Job no SY140167

11/11/2014

Central Park Block 11 – Preliminary fire safety engineering review

Basement 01 Plan

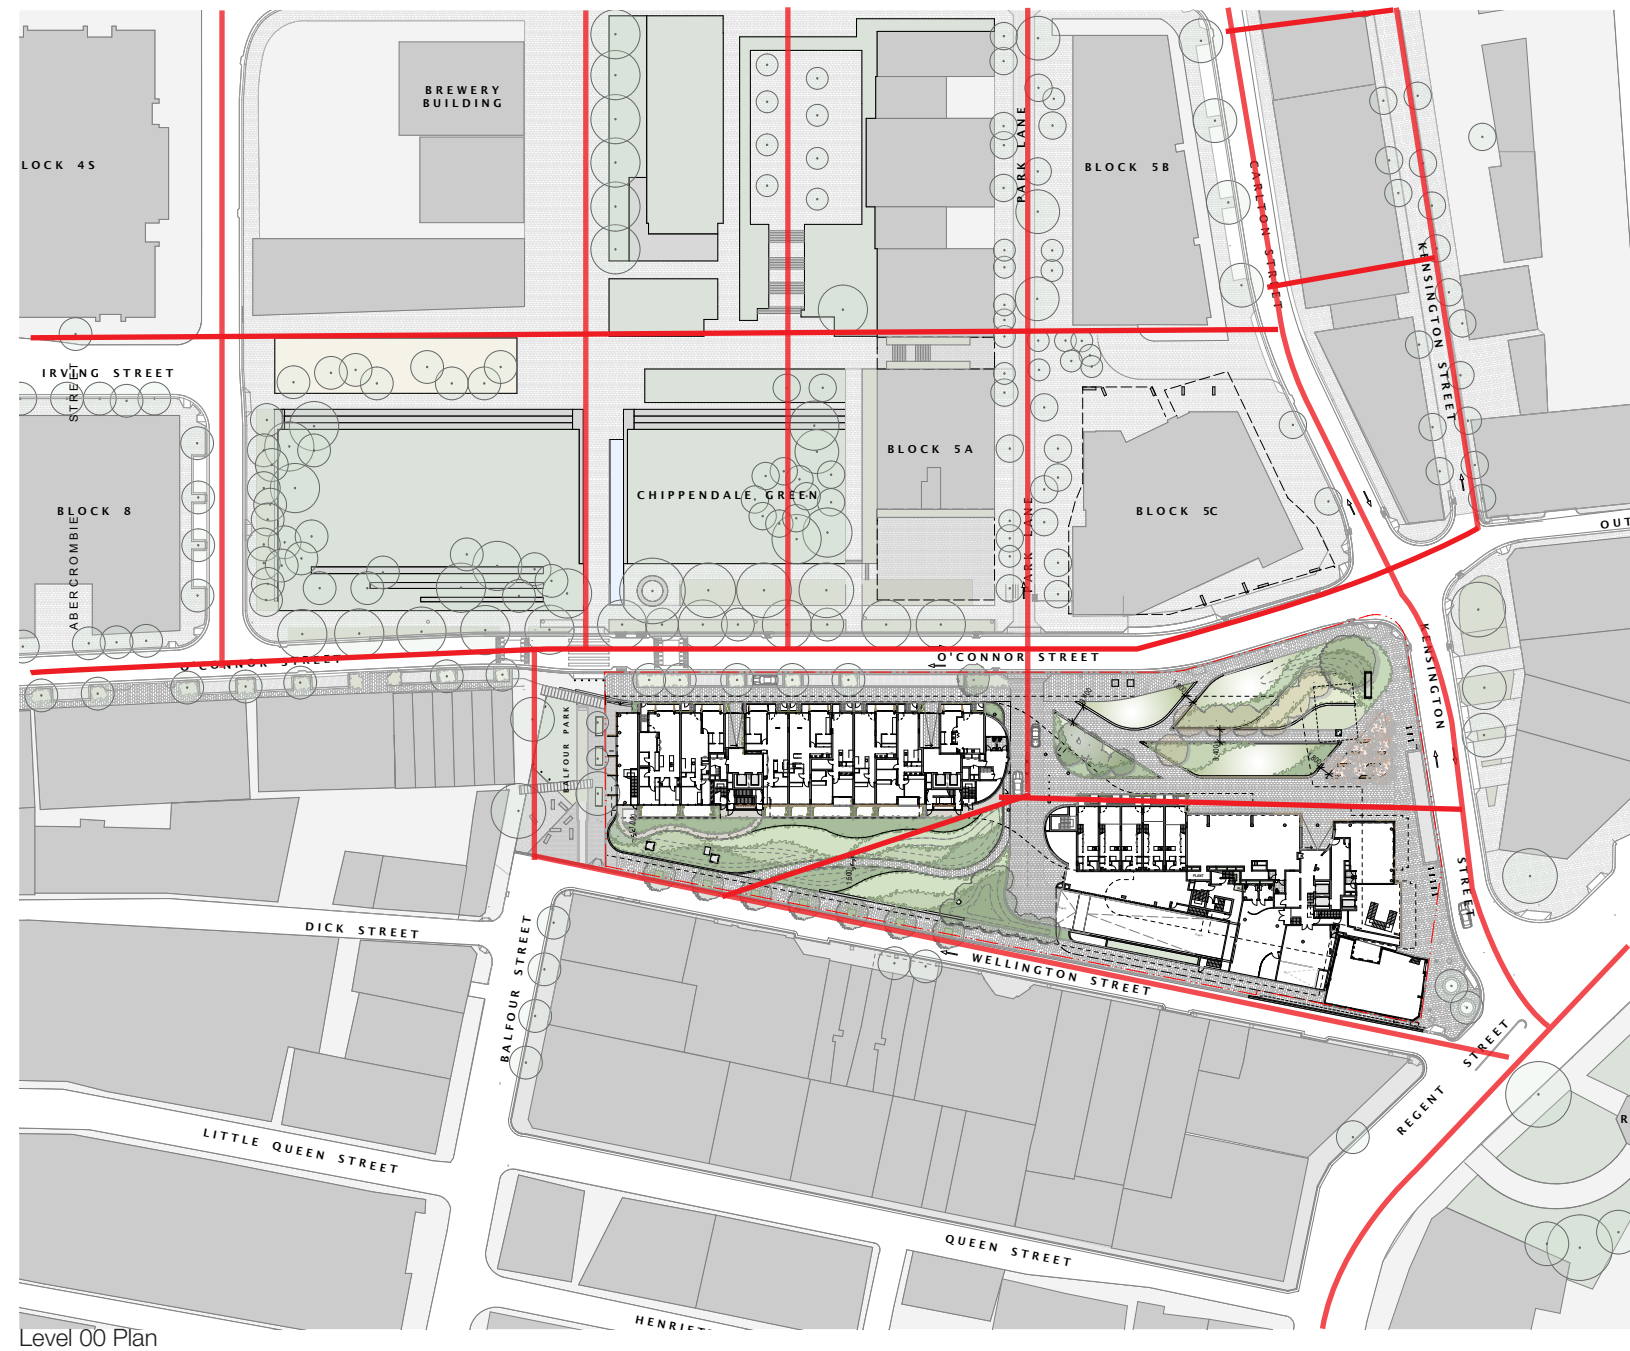
2.	The class 7b storage areas within the basement carpark B2 may exceed 10% of the total floor area in aggregate. The maximum fire rating of the basement levels is proposed to be reduced to 120 minutes in lieu of 240 minutes required for class 7b use.	Specification C1.1	CP1 and CP2	Individual storage areas must be limited to not more than 10% of the total floor area of the storey. Where appropriate physical separation cannot be achieved, further fire separation of the storage areas may be necessary.

7.	The design includes the following extended travel distances from the basement levels: - The area around B1 car spaces 8 to 12 that is more than 40m to exit. Up to 48m to nearest exit. - Egress from the energy transfer station is 24.5m to a point of choice on an open floor plan. - The maximum travel distance between alternative exits measured via the point of choice in the western storage area on basement 2 is 105m.	Clause D1.4 and D1.5	DP4 and EP2.2	The areas identified represent minor departure from the DTS provisions and can be addressed by an alternative solution.

RESIDENTIAL - TYPICAL PLANS LEVEL 4-6

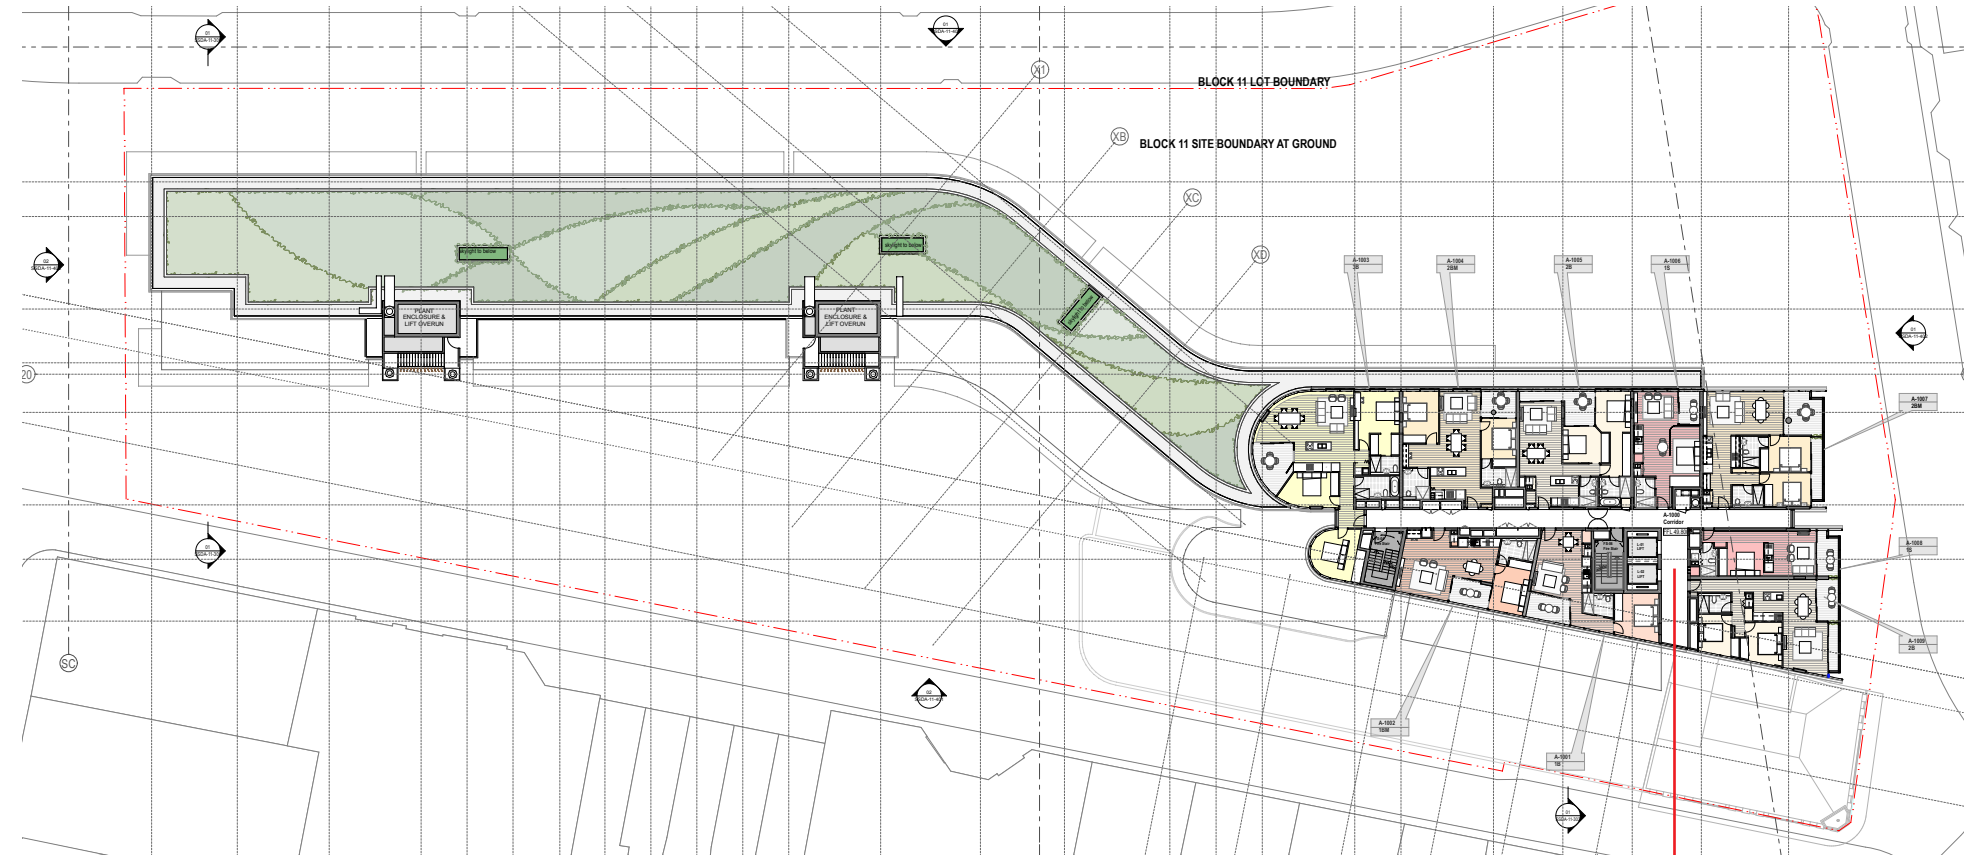
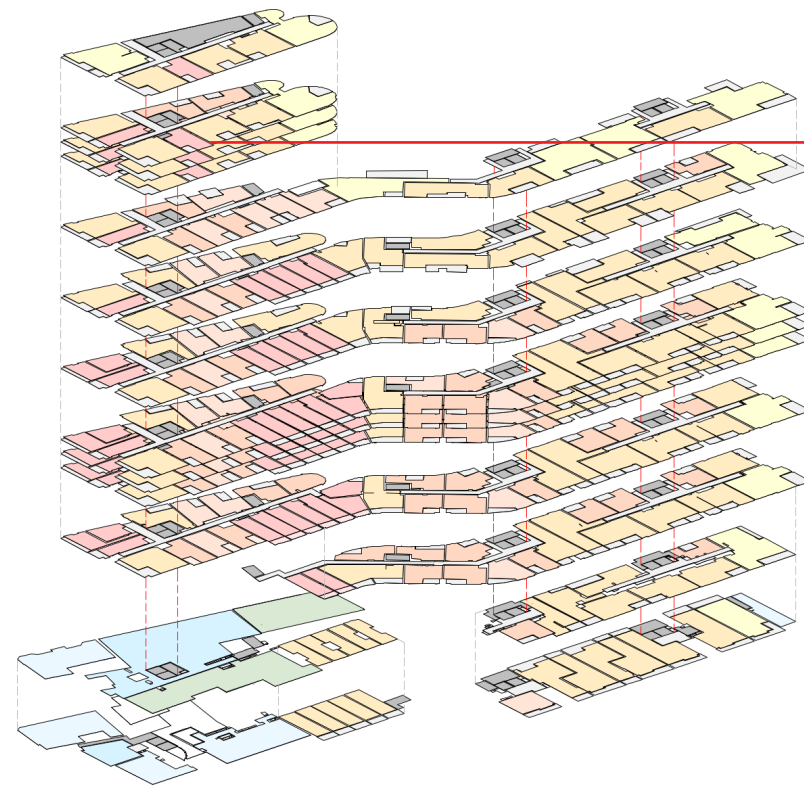
Item	Description of alternative solution	DTS provision	Performance requirement	Comment
1.	The building contains public corridors more than 40m in length, without division by smoke walls and doors, as follows: - Level 2 - 8 west: 43m - Level 10 - 13 : 47m	Clause C2.14	CP2 and DP4	The minor increase in corridor length can be addressed an al alternative solution considering the general reduction in hazard resulting from sprinkler protection.
